**A66 Northern Trans-Pennine Project
TR010062**

**3.4 Environmental Statement
Appendix 10.1 Landscape and Visual
Policy and Consultation Tables**

**3.4 ENVIRONMENTAL STATEMENT APPENDIX 10.1
LANDSCAPE AND VISUAL POLICY AND CONSULTATION
TABLES**

Project Name A66 Northern Trans-Pennine																										
Map Title Figure 10.9.801 - Viewpoint Photomontage Cross Lanes to Rokeby Year 1																										
P01

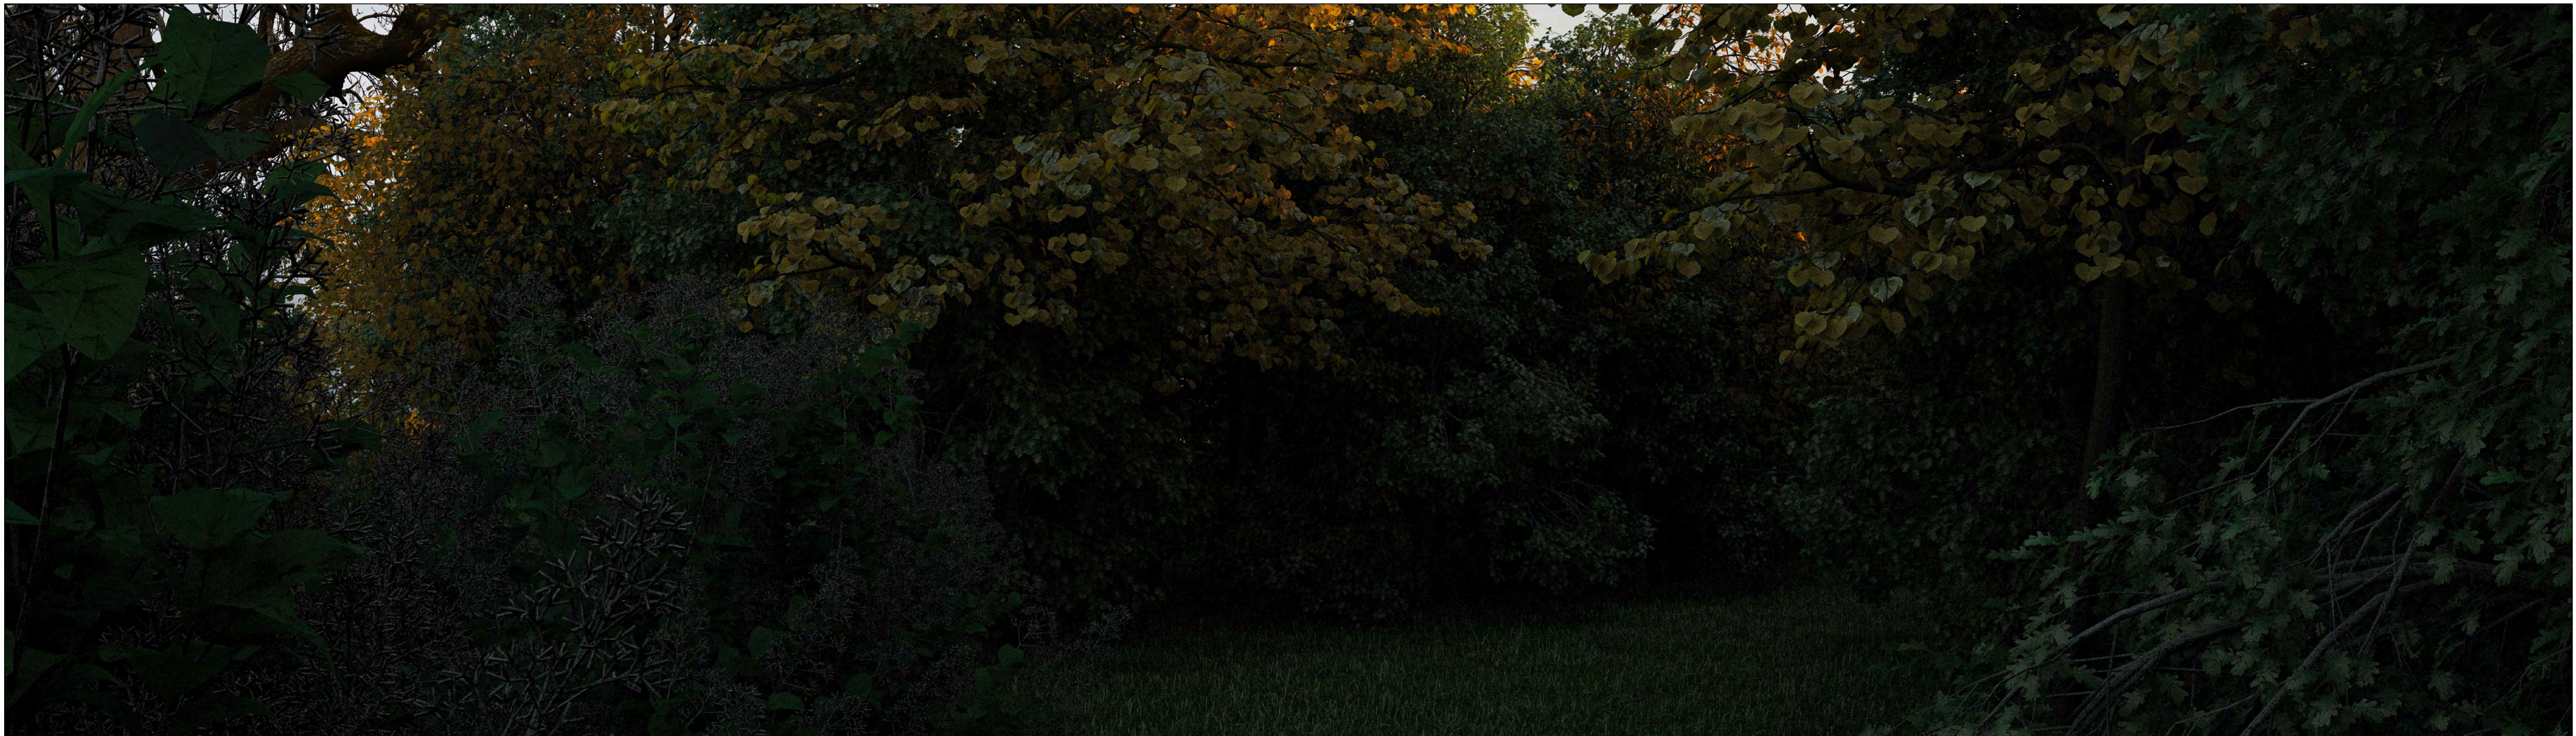
East & West Layton & Carkin Parish	Visual amenity and key viewpoints at paragraph 11.5.19 should include the views from East and West Layton, including the land between the two villages where the views open out and will be significantly impacted by the new road	Viewpoints 9.1, 9.2 and 9.7 are at West Layton, land between the villages and East Layton respectively. In addition, viewpoint 9.6 is on a bridleway to the south of East Layton.	Section 10.7: Baseline conditions.
East & West Layton & Carkin Parish	Paragraphs 11.7 are light on detail	Scheme design and mitigation design have been developed and are included in the ES and PDP.	Section 10.9: Embedded and essential mitigation and enhancement measures. DCO Document 5.11 Project Design Principles
East & West Layton & Carkin Parish	We note paragraphs 11.8.39-41 describe the negative material impact on the Stephen Bank to Carkin Moor section without any suggestion as to how these will be	Mitigation measures have been designed through inter-disciplinary working with regard to the	Section 10.9: Embedded and essential mitigation and
